# Norfolk Boreas Offshore Wind Farm Applicant's Comments on Deadline 10 Submissions and Other Submissions

Applicant: Norfolk Boreas Limited  
Document Reference: ExA.ASR.D11.V1  
Deadline 11

Date: May 2020  
Revision: Version 1  
Author: Royal HaskoningDHV

PZ  
PZ  
PZ  
PZ  
PZ

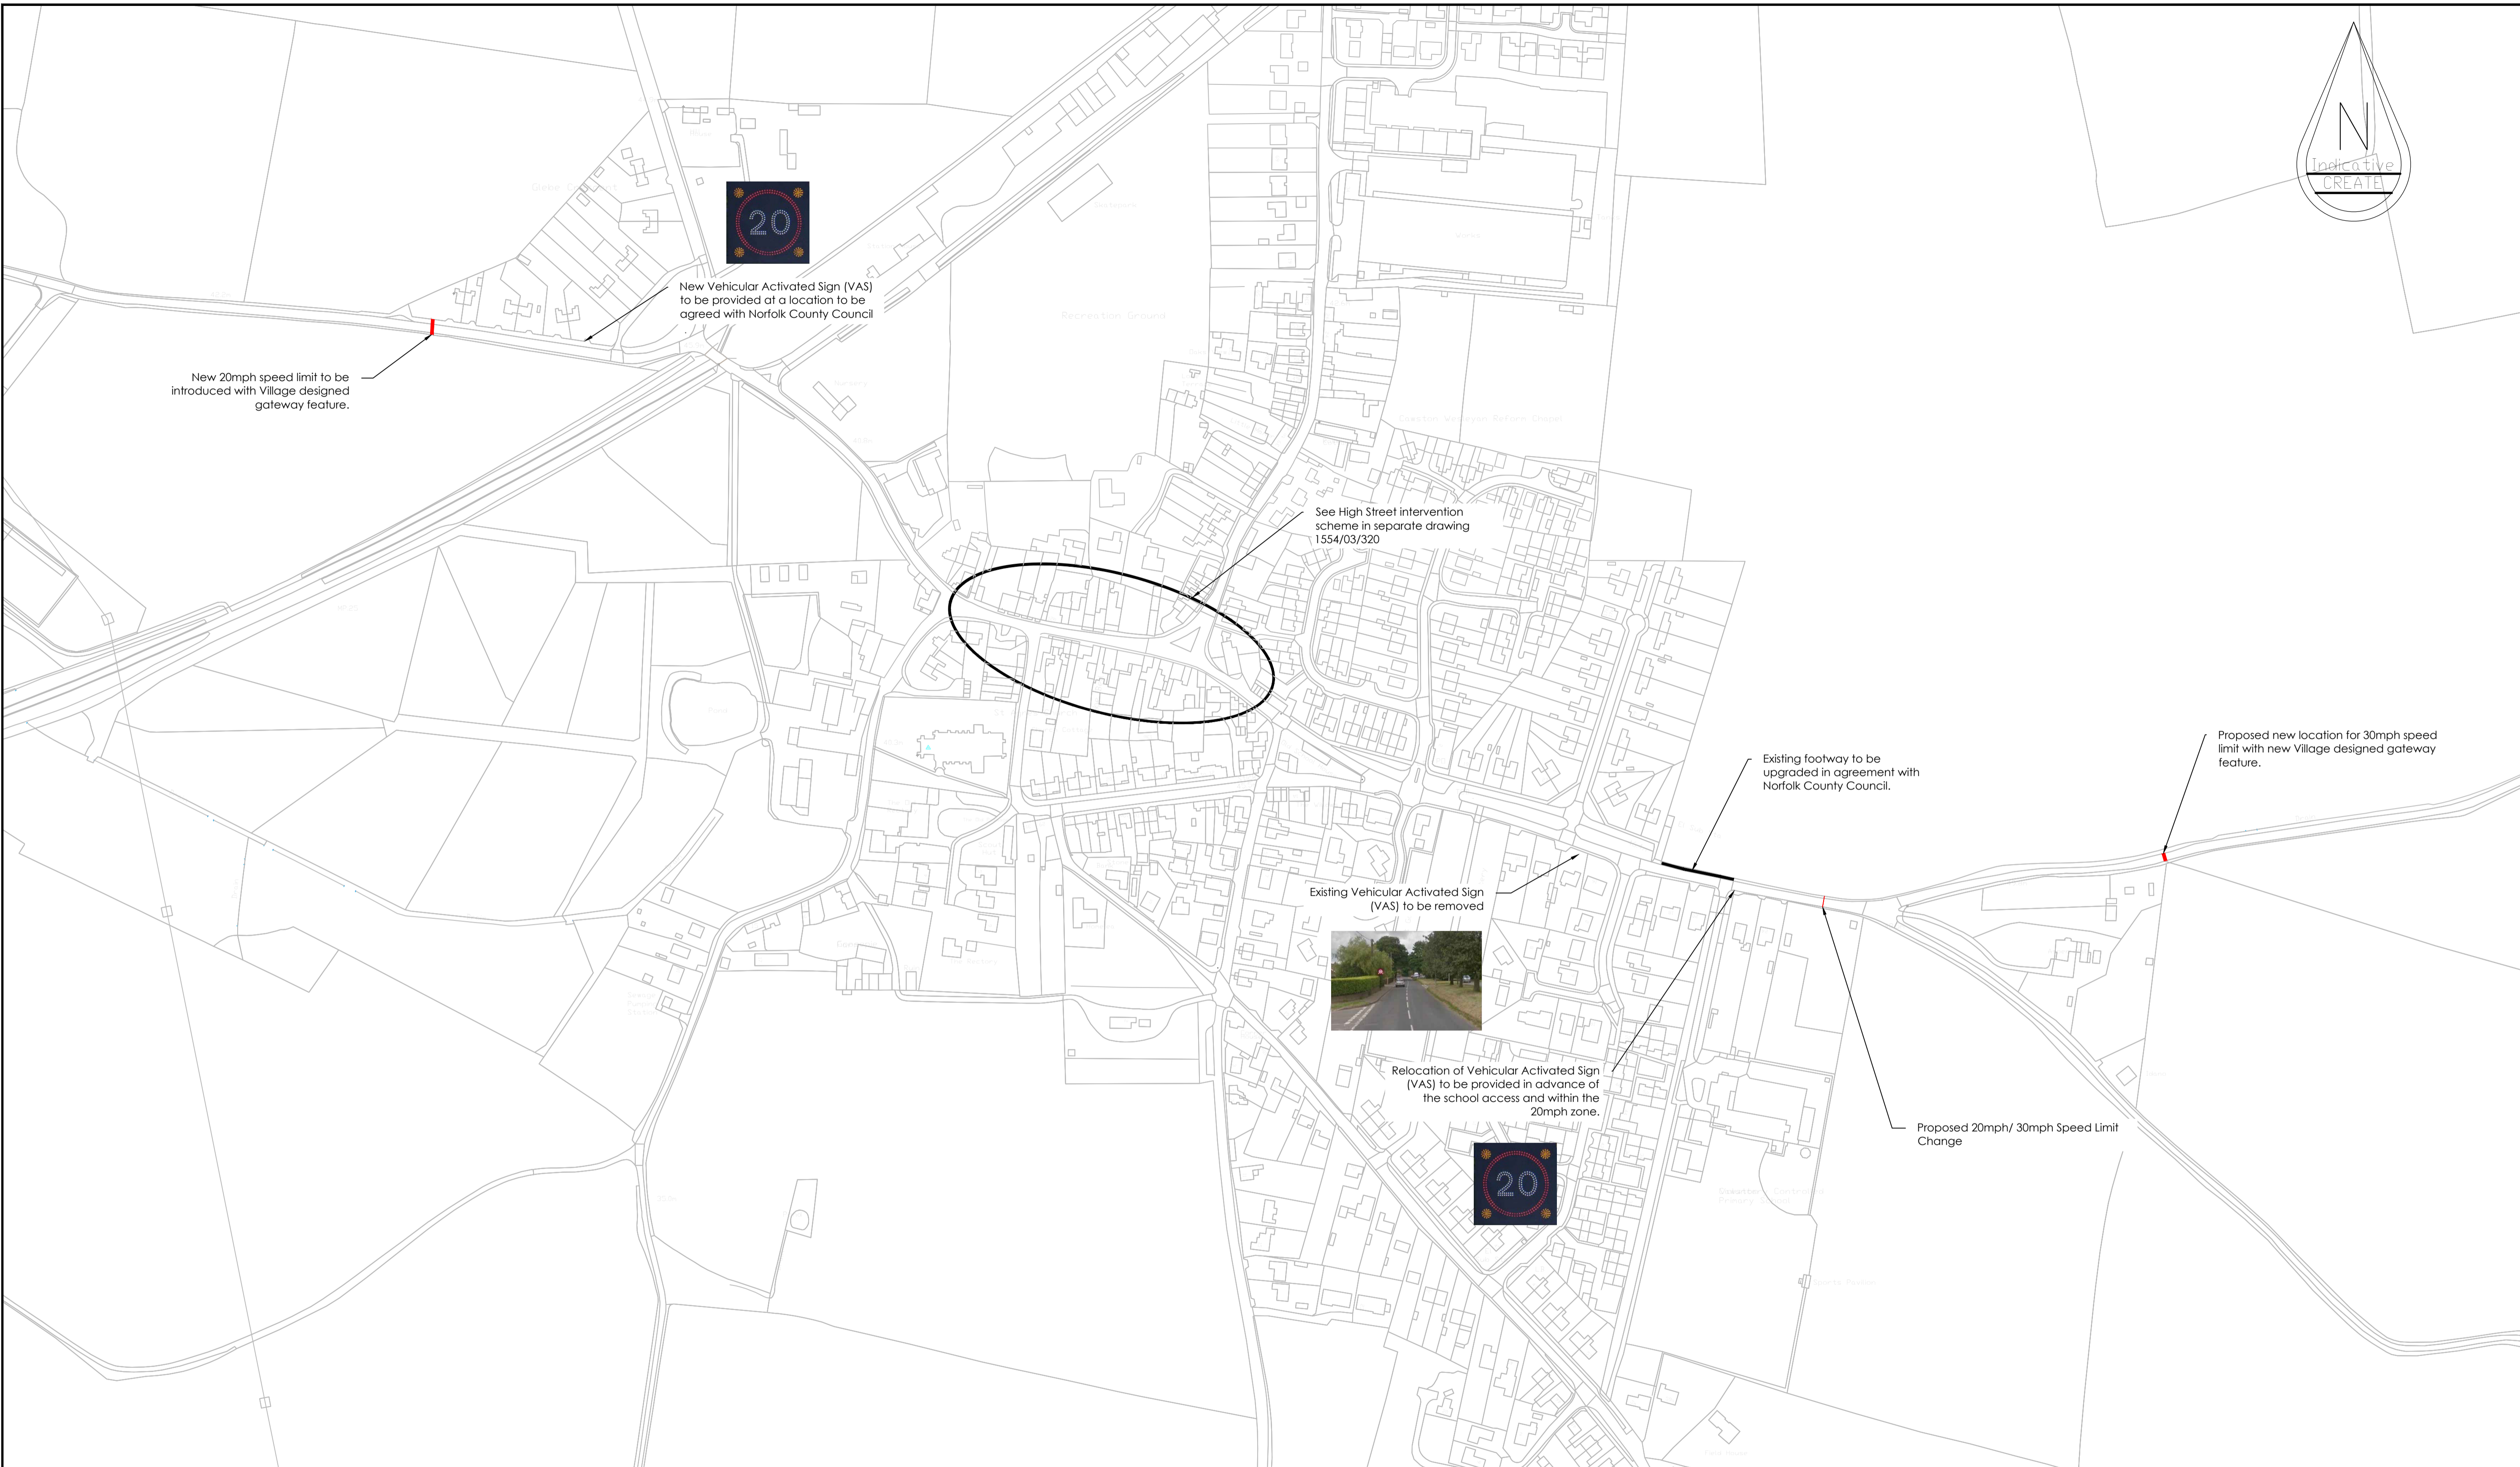
Summary of Submission	Applicant's Comments
<p>The additional width of vehicles from wing mirrors is not shown in the drawings and even in the areas designated for passing the additional width for two sets of wing mirrors and a safe passing distance between them is not evident.</p> <p>Cawston Parish Council views the proposed HIS to be flawed and impractical. For the scheme to have any hope of operating as designed a number of conditions need to be satisfied which include:</p> <ol style="list-style-type: none"> <li>1. The ability of all HGV drivers to be able to see oncoming traffic around corners on the bend at the railway bridge, on the bend by the Old Forge and on the bend close to White House Farm</li> <li>2. A requirement for all HGVs, not only the Applicant's and/or Hornsea 3 project HGVs, to arrive at evenly spaced intervals</li> <li>3. Where two HGVs approach from either East or West they must not have any other road traffic between so they can fit in the proposed system of "passing places". Any train of vehicles longer than the planned "passing space", which is designed for two HGV lengths, will obstruct passing manoeuvres and make gridlock more likely.</li> </ol> <p>Norfolk County Council echoes some of CPC's concerns. The Applicant's Statement of Common Ground with NCC states that:</p> <p>NCC have raised a concern with regard to driver compliance, drivers may potentially fail to yield at pinch points causing traffic to back up, inducing unacceptable delays.</p> <p>In their letter of 27th April (REP8-036) NCC also reiterate their concerns that the HIS could fail</p> <ol style="list-style-type: none"> <li>1. If parking occurs outside the designated parking areas</li> <li>2. Traffic fails to yield at the correct points</li> <li>3. Or if traffic speeds are much higher than 20mph.</li> </ol> <p>Residents of Cawston already see all three of these conditions on a daily basis, and our D6 submission (REP6-042) noted official Government sources showing that 20mph limits</p>	<p><b>Narrow footways</b></p> <p>[REP5-055] Revised Cawston Highway Intervention Scheme Road Safety Audit Decision Log ('RSA log') reports that the Road Safety Audit (RSA) recognises that the likelihood of pedestrian/vehicle conflicts has been reduced by the HIS key design principles of:</p> <ul style="list-style-type: none"> <li>• Providing adequate road space for HGVs to traverse the High Street without the requirement to mount or project over the pavement;</li> <li>• Protecting adequate road space for the HGV routes with the introduction of formal parking controls;</li> <li>• Advance sign warning of 'pinch points'; and</li> <li>• The introduction of a mandatory 20mph limit.</li> </ul> <p>The RSA notes there may be a residual perceived risk to pedestrians and makes the following recommendations:</p> <ul style="list-style-type: none"> <li>• Introduce measures to highlight the presence of pedestrians within the area;</li> <li>• Introduce road markings and 20mph signage at the gateways allowing for maximum impact and awareness;</li> <li>• Provide maximum footway area, by attaching all signs to existing street furniture where possible and introducing any new signposts to the back of the footway, reducing footway clutter.</li> <li>• Review the compliance of drivers following the introduction of the reduced speed limits and introduce further measures if necessary.</li> </ul> <p>The Applicant has accepted all of these recommendations and has incorporated them into the finalised HIS design (detailed in the OTMP [REP10-016]. The Applicant therefore reiterates the conclusion of the RSA log [REP5-055]:</p> <p><i>"Following the evaluation of the key effects that are likely to influence pedestrian risk it is concluded that the likelihood and severity are low and</i></p>

Summary of Submission	Applicant's Comments
	<p>a 20mph speed limit to enable HGV drivers to safely react to the highway environment and 'yield' to oncoming HGVs as required.</p> <p>The HIS design has been informed by a full topographical survey and demonstrates the swept path simulation of the largest UK standard HGV; a 44t articulated tractor and semi-trailer, 2.55m wide trailer, 2.49m cab width and 0.25m wide wing mirrors.</p> <p>In respect of HGV arrival/regulation, the HIS scheme design has been developed to accommodate an even arrival profile for the Project's HGVs (the management of which is secured in the OTMP [REP10-016]) and a random arrival pattern for non-Project HGVs.</p> <p>An intensive monitoring regime and further driver compliance intervention measures were introduced at Deadline 8 in the Outline Traffic Management Plan (V4) [REP8-008] to accommodate the RSA recommendations. In addition, in response to NCC's request for clarification, the text has been refined, as agreed with NCC, and is included in the OTMP (Version 5) submitted at Deadline 10 [REP10-016]. Agreement is confirmed in both the final Statement of Common Ground with Norfolk County Council (Version 3) [REP9-015] and the Applicant's Joint Final Position Statement with Norfolk County Council Highway Intervention Scheme, Cawston (ExA.AS-1.D11.V1) to be submitted at Deadline 11. The range of measures to enable targeted intervention on validation of a driver compliance issue are as follows:</p> <ul style="list-style-type: none"> <li>• Applying the OTMP 'breach' corrective process identified in Section 5.4 and 5.5 to the supply chain;</li> <li>• Further hazard signing;</li> <li>• Introducing mandatory priority 'give-way';</li> <li>• Increased parking enforcement;</li> <li>• A reduction in the cumulative HGV cap (239 HGV movements) by ensuring Norfolk Boreas and Hornsea Project Three traffic demand does not overlap; and</li> <li>• Incrementally reducing the volume of traffic passing through Cawston from 239 HGV movements through targeted intervention</li> </ul>
